DRB Application No.: 06DRB-01613 (P&F)
Project Name: CARLOS REY SUBDIVISION
Agent: Jose Rodriguez

Project # 1005250
Phone No.: 610-0593

DEVELOPMENT REVIEW BOARD – SPEED MEMO

DRB CASE NO/PROJECT NO: 1005250

All lots with F-1 designated on PLAT OF
LOTS A-1, A-2, B-1, B-2, C-1, C-2, BLOCK T-1
CARLOS REY SUBDIVISION

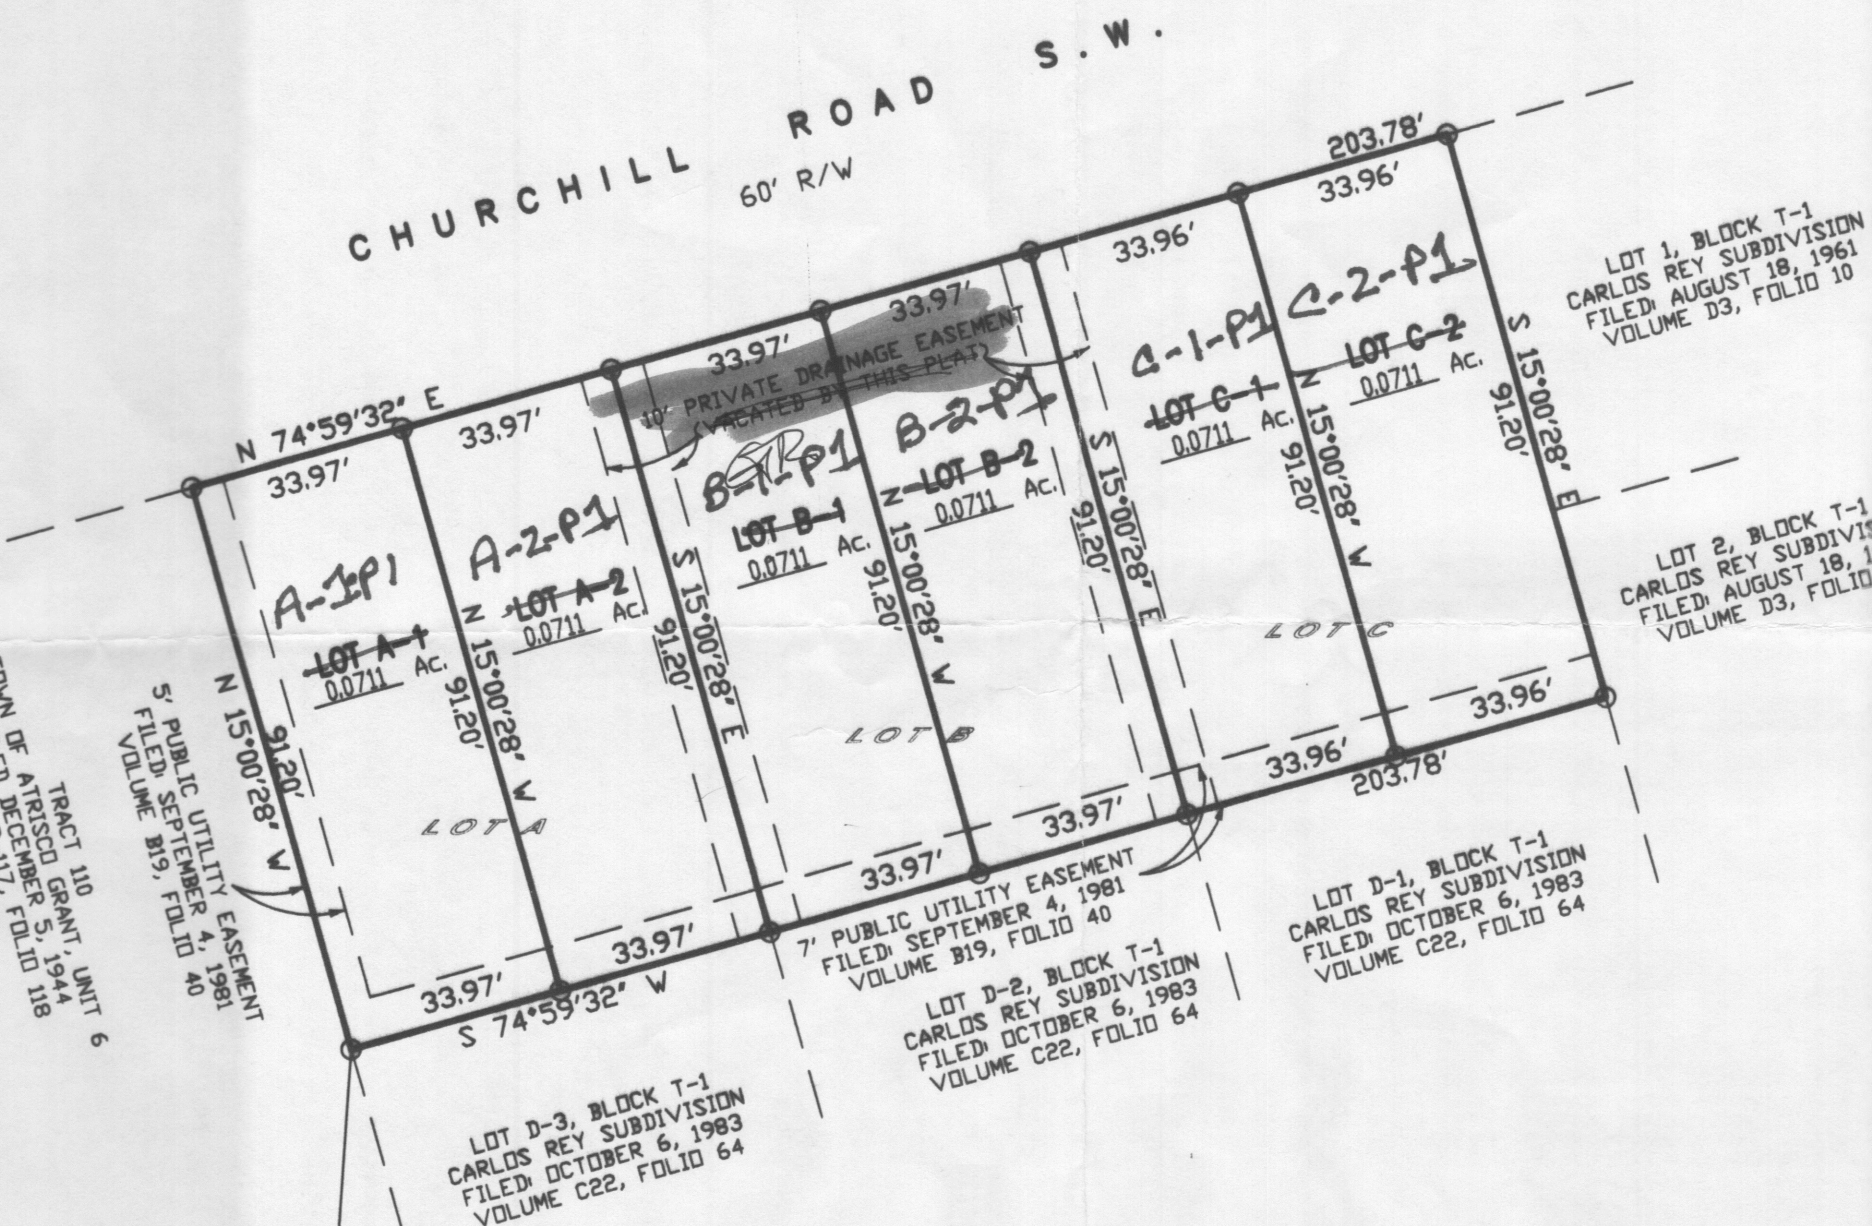
- TRANSPORTATION: Rodriguez
- _____
- _____
- _____
- _____
- UTILITIES: _____
- _____
- _____
- _____
- CITY ENGINEER / AMAFCA: _____
- _____
- _____
- _____
- PARKS / CIP: _____
- _____
- _____
- _____
- PLANNING (Last to sign): Record
- P-1 designation on all lots
- _____
- _____

JOSE RODRIGUEZ request(s) the above action(s) for all or a portion of Lot(s) A, B & C, Block T-1, **CARLOS REY SUBDIVISION**, zoned R-2 residential zone, located on CHURCHILL RD SW, between COORS BLVD SW and BATAAN DR SW containing approximately 1 acre(s). [*Deferred from 11/15/06 & 11/22/06 & 11/29/06 & 12/6/06*] [*Indef deferred from 12/13/06*] (K-10) **THE FINAL PLAT WAS APPROVED WITH FINAL SIGN OFF DELEGATED TO PLANNING FOR P-1 LOT DESIGNATIONS ON THE PLAN AND TO RECORD.**

"INFRASTRUCTURE CERTIFICATION" GRADING AND DRAINAGE PLAN

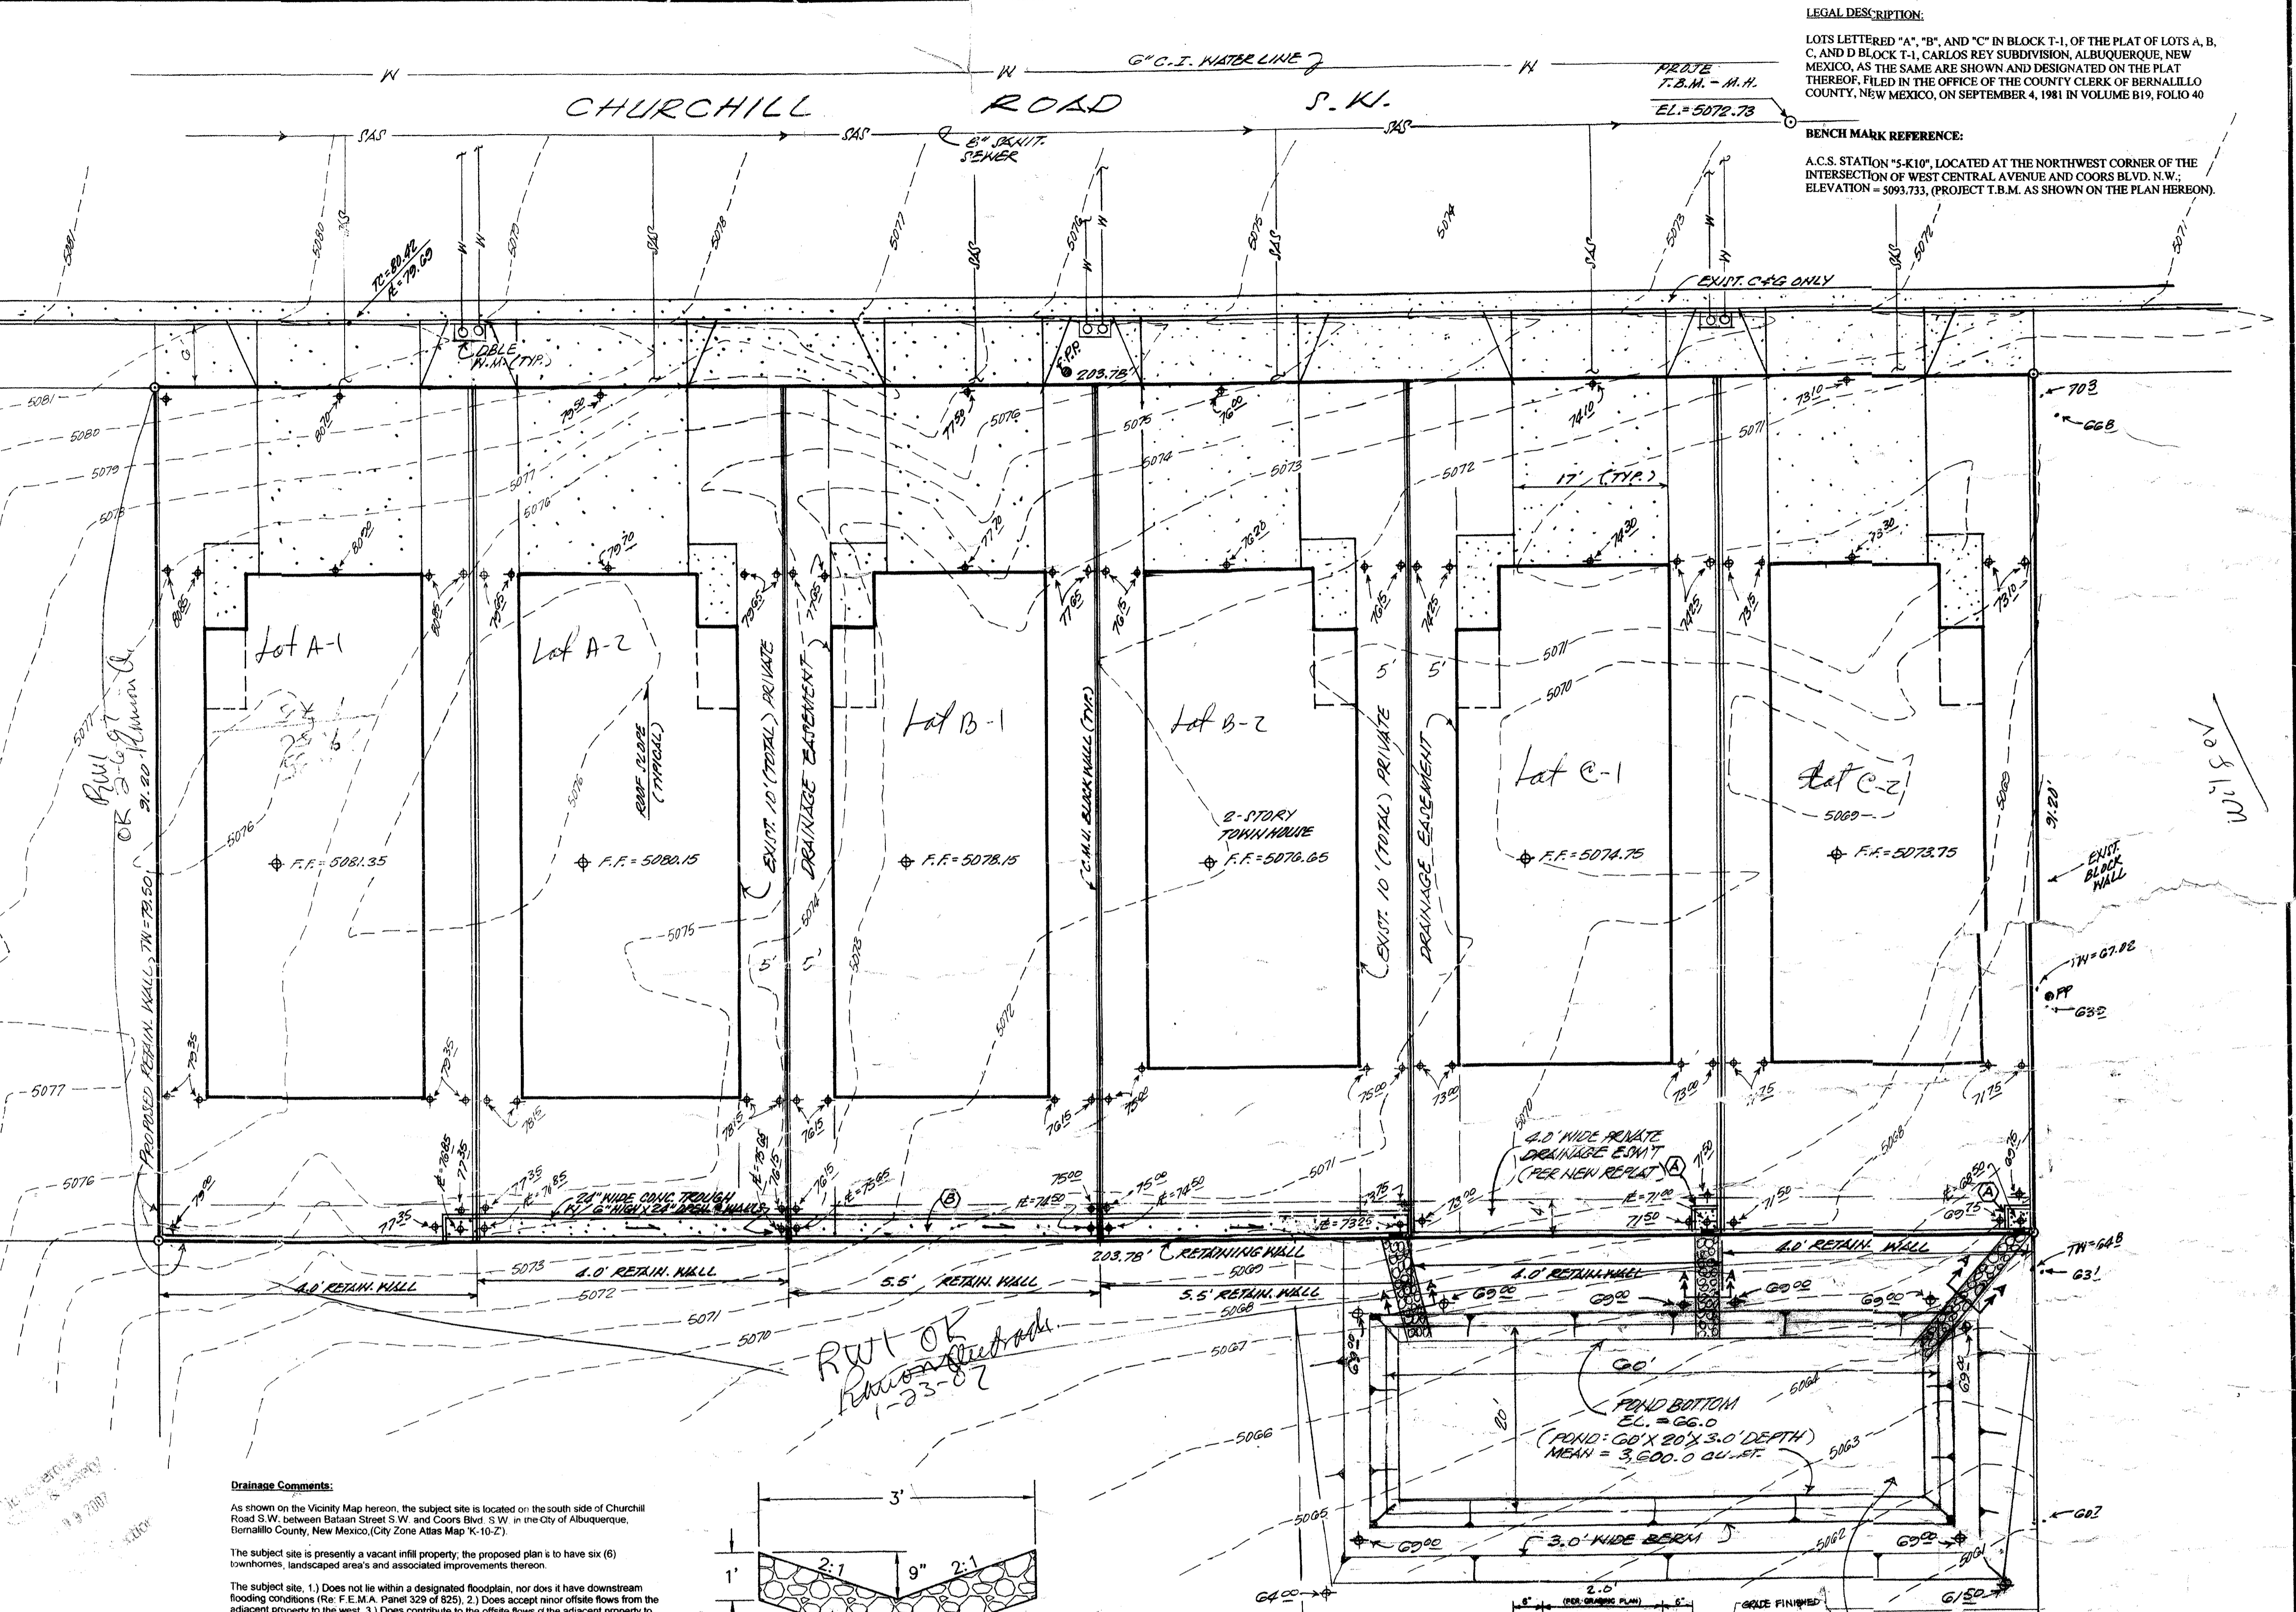
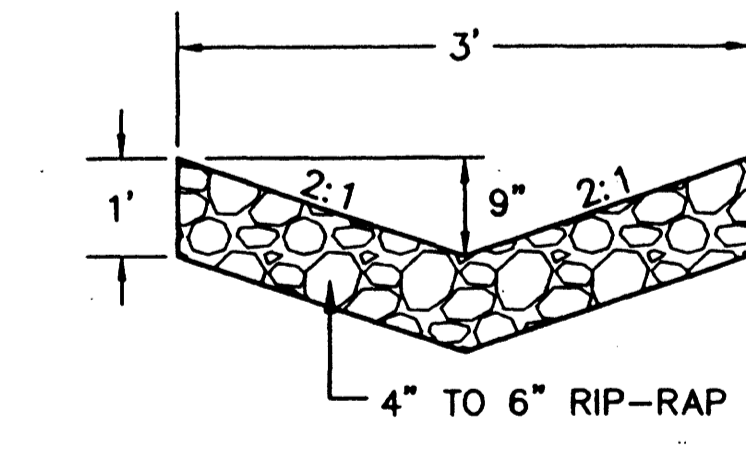
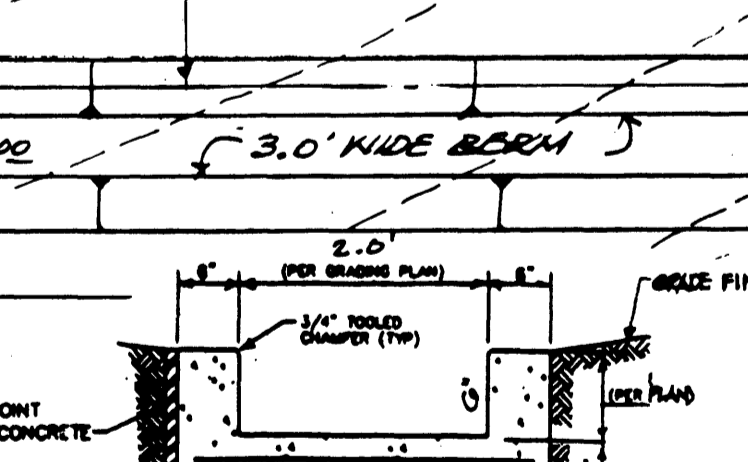
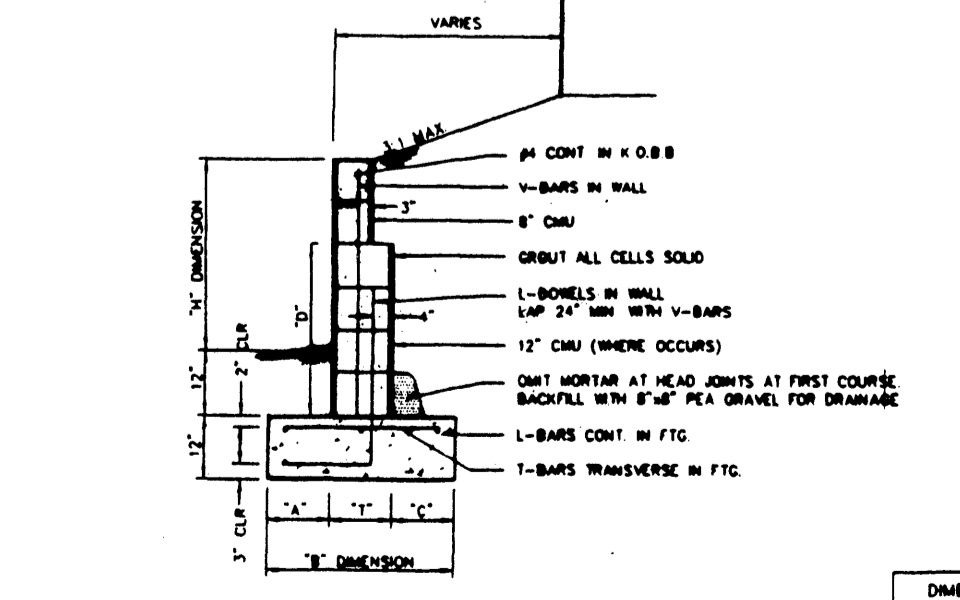
An approved grading and drainage certification is required prior to final plat approval.
